Laurie Leader - Re: BP#2014-01766 10 Mellen Street - Plan review comments

I am reviewing the plans for 10 Mellen Street. Can you please clarify the following initial questions:

1  
A1.2  
2nd Floor Plan  
SCALE: 1/4" = 1'-0"

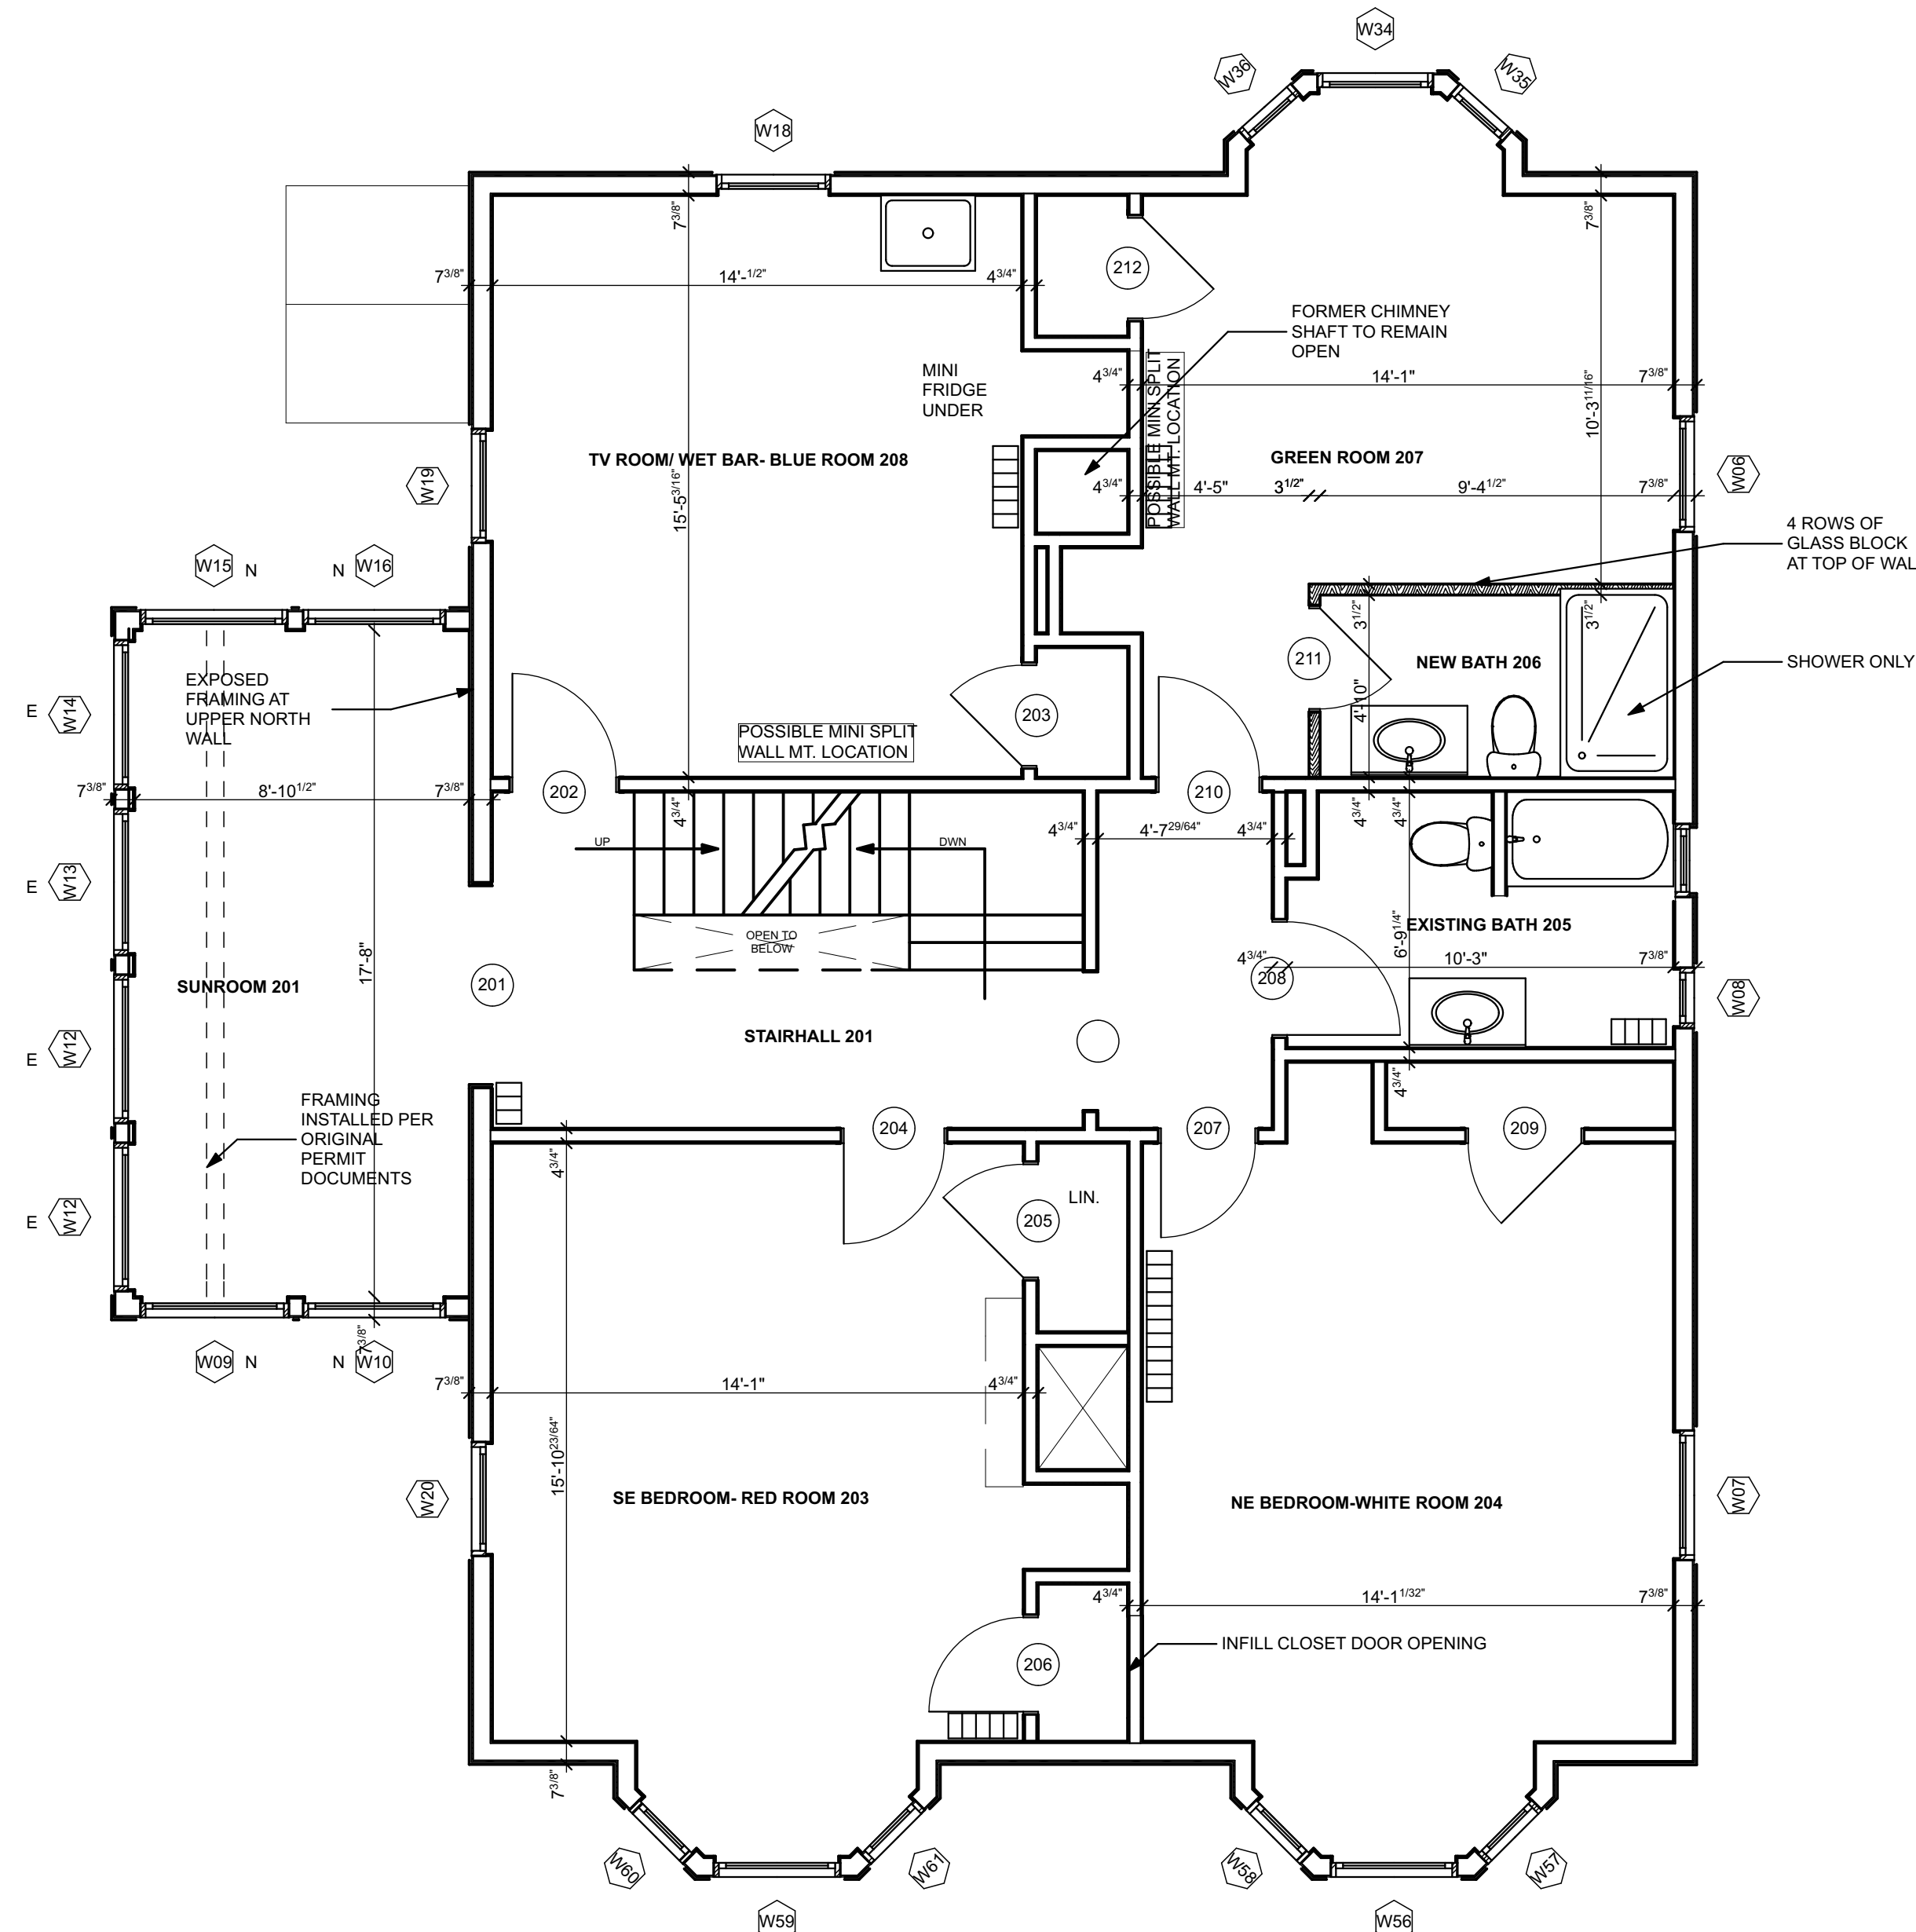
1. According to the project scope, the only carpentry work is associated with the 2nd floor sunroom and an additional LVL for the kitchen ceiling. It is not clear where the LVL is being installed on the floor plans. Please clarify. Also, it is not clear what framing work is being done to the 2nd floor sunroom. Please clarify this as well.
2. Provide specifications for LVL's.

The lvl in the kithchen is located in the center of kithchen area, 3' from the bay window running perpendicular to the wall, as it is a balloon framed home. This replaces a preexisting beam that had several areas of damage due to overzealous previous home improvement and age.

The lvl in the sunroom is located on the front wall of the sunroom, and again is a replacement for a preexisting yet failing structural member. The front wall of the sunroom had been compromised by water for many years and was near collapse. The front wall was rebuilt using typical framing and the lvl is used as window header to distribute wieght from above.

The lvl ASTM D5456 is of typical constuction, 1 3/4" thick x 12" tall, and run in pairs. Pairs have been nailed together using manufacturers recomendations.
